From: [Sarah Fletcher](#)
To: [Robin Proebsting](#)
Subject: Re: Draft EIS for East Seattle School (SEP17-020) now available
Date: Sunday, February 23, 2020 8:32:47 PM

This email is to let you know that the Draft Environmental Impact Statement (DEIS) for project SEP17-020, reviewing impacts associated with the proposed demolition of the East Seattle School, is now available. You are receiving this email because you previously commented on this SEPA review or requested to be kept informed about this project. As a courtesy, I have attached a copy for you to review.

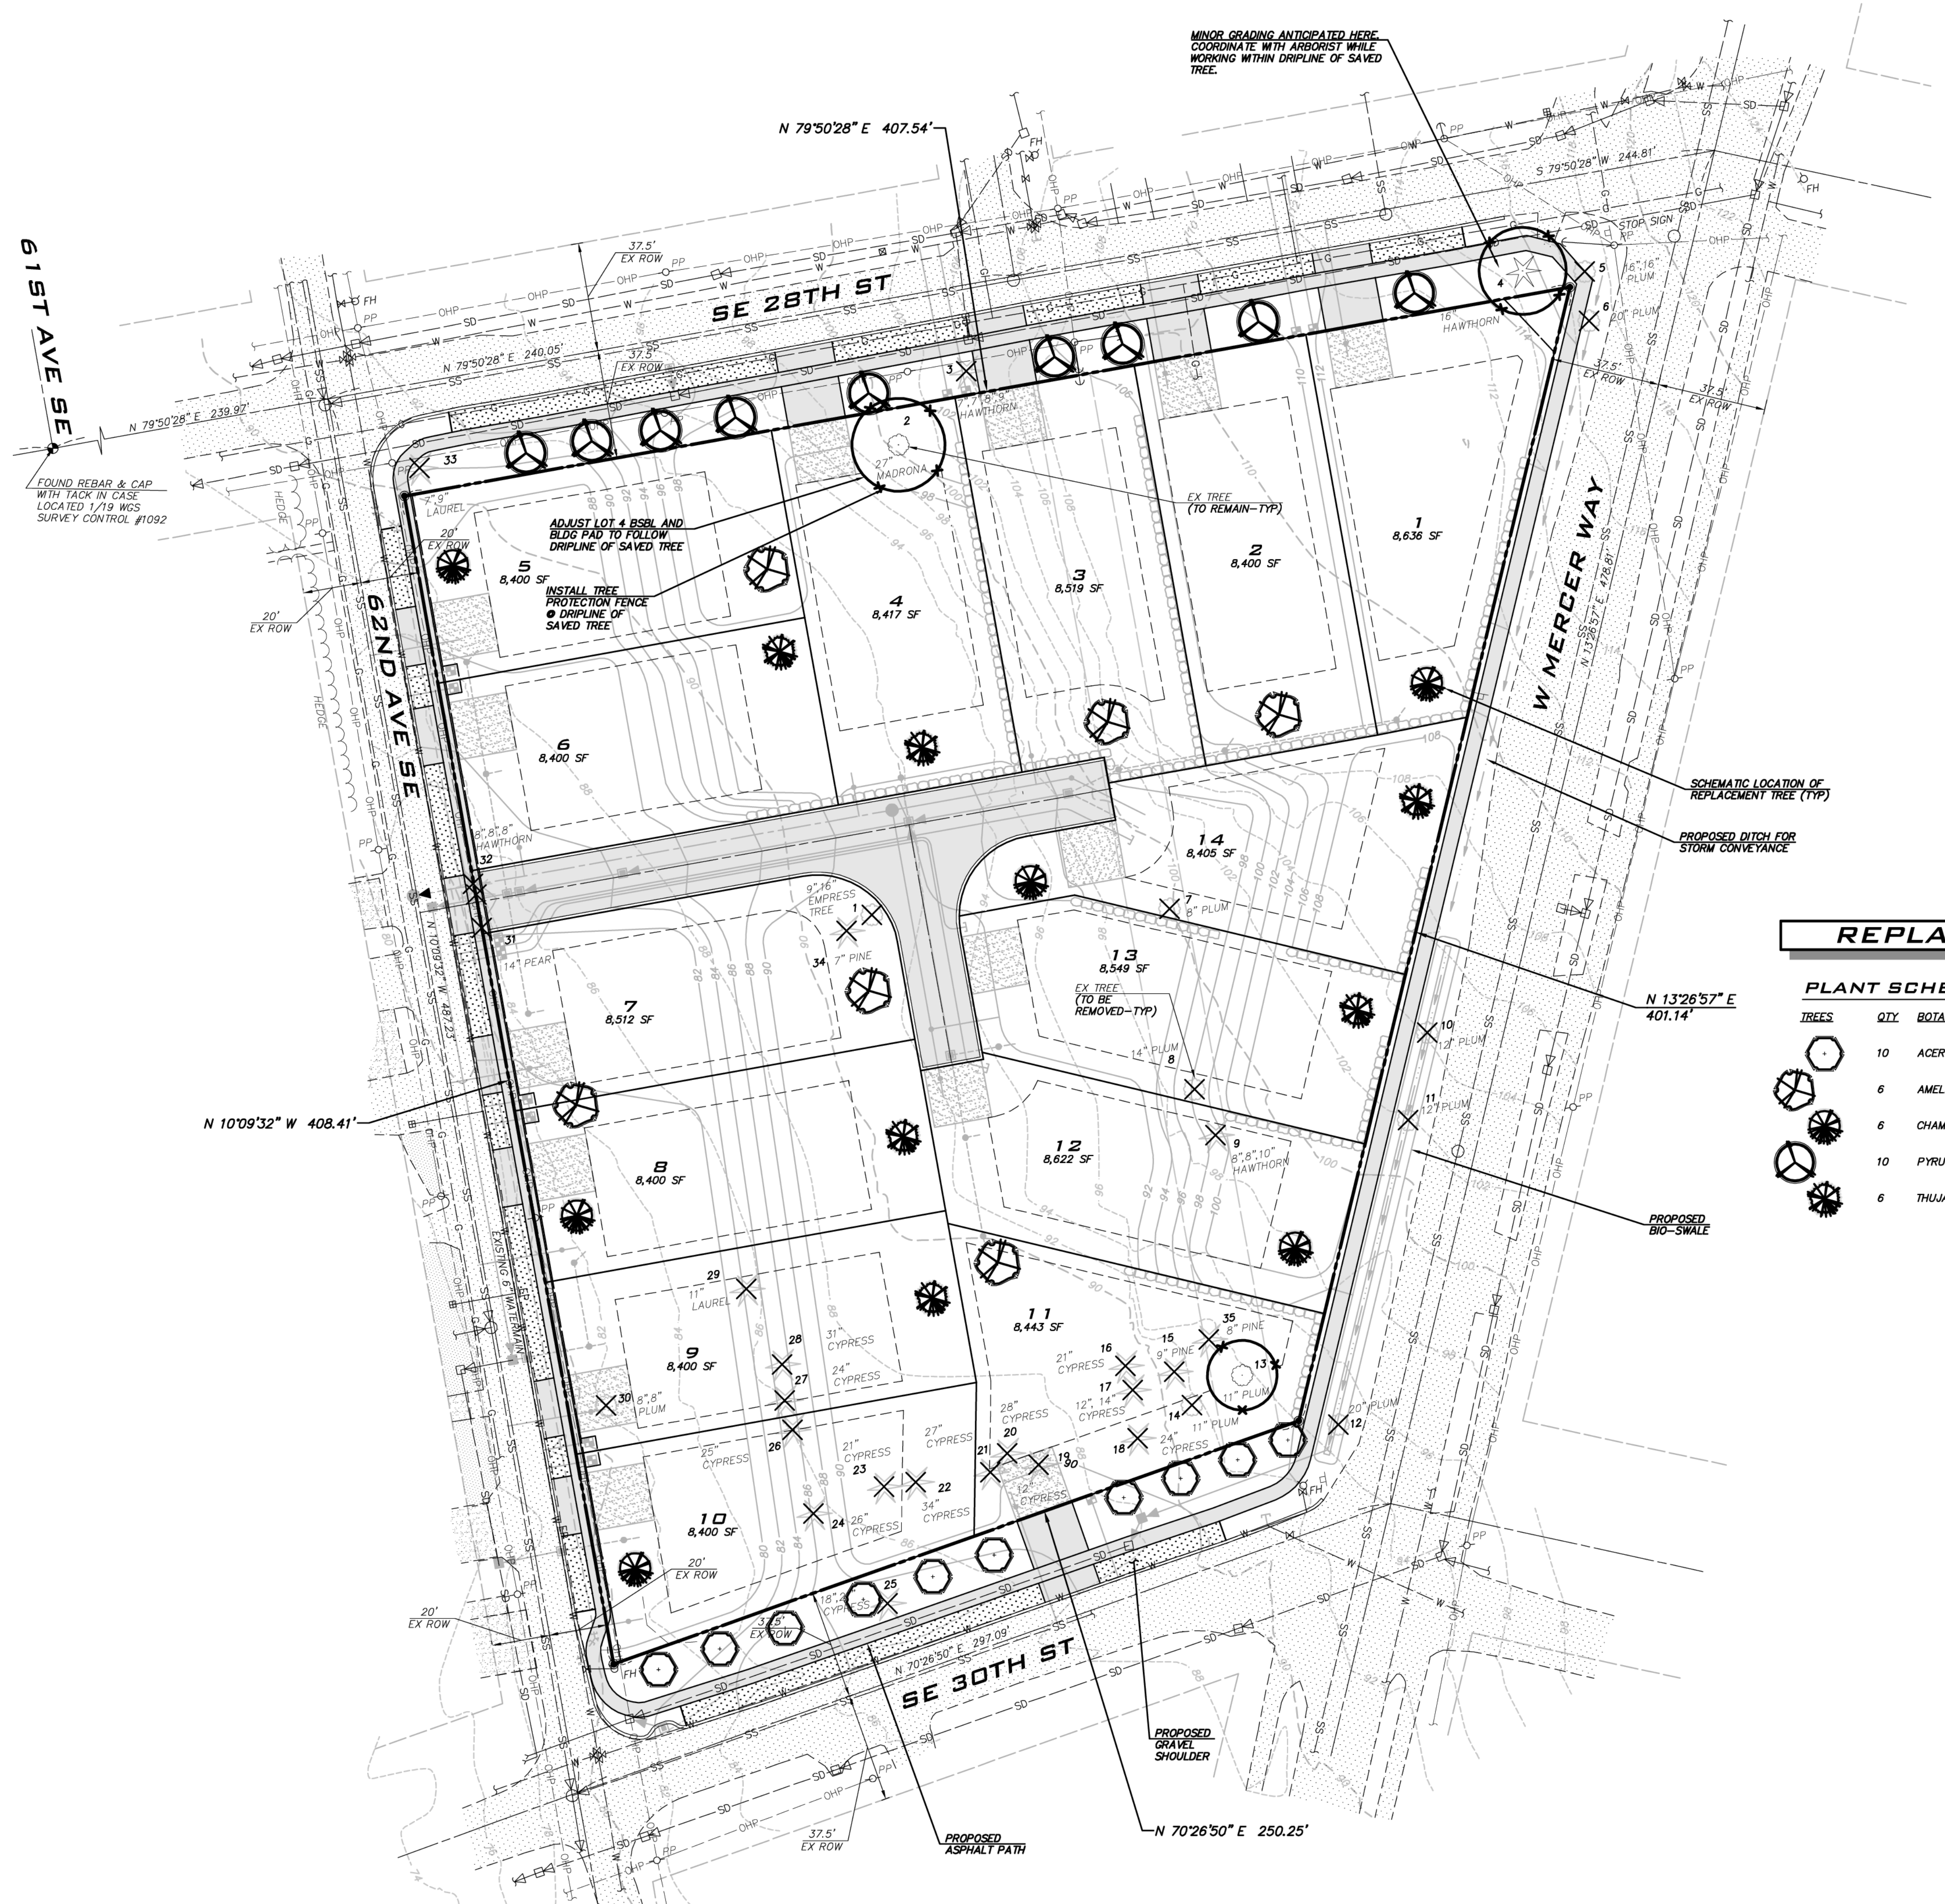
And if you look at tree nos. 25, 29, 33, as examples, it says that the trees are "viable," but then, if you look on the last page, it has "X's" marked for them to be removed. What's more, on the plan, there are two more Pine trees (7" and 9" respectively, nos. '34' and '35' were on the list of trees on the property, but it shows those two as being removed on the plan (the last page of the attachment).

So, out of all the trees on the property, does it look like to you that just **one** will remain? So not altogether, clearcutting because they saved all of ONE TREE. It says in the Code: "Percentage of trees to be retained ((A-B)/Ax100) note: must be at least 30%." There are 35 trees if you include the two other Pine trees, so saving one tree out of 35 is **2.857%**, it is certainly nowhere near the **30% of trees which have to be retained**. So, they are going to have to save more trees. John, did you ask them to retain the 30% and what did they say when you told them they had to retain **30%**? And the hedges give privacy, what is going to provide privacy if all, but one of the trees, is removed?

Second, neither trees that have been maintained as a hedge (for example, many of the Leyland cypresses including tree 29), nor non-viable trees, nor trees with a diameter under 10 inches are counted for the purpose of calculating the 30% retention requirement. Trees 34 and 35, for example, have diameters of less than 10 inches, and are therefore not part of the calculation that determines tree retention required during subdivision (see [MICC 19.10.060\(A\)\(2\)\(a\)](#): “A minimum of 30 percent of trees with a diameter of 10 inches or greater, or that otherwise meet the definition of large tree, shall be retained over a rolling five-year period.”) Note as well that in the first review letter, staff relayed to the applicant that tree 25 needed to be retained and requested confirmation that at least 30% of regulated trees were retained and protected.
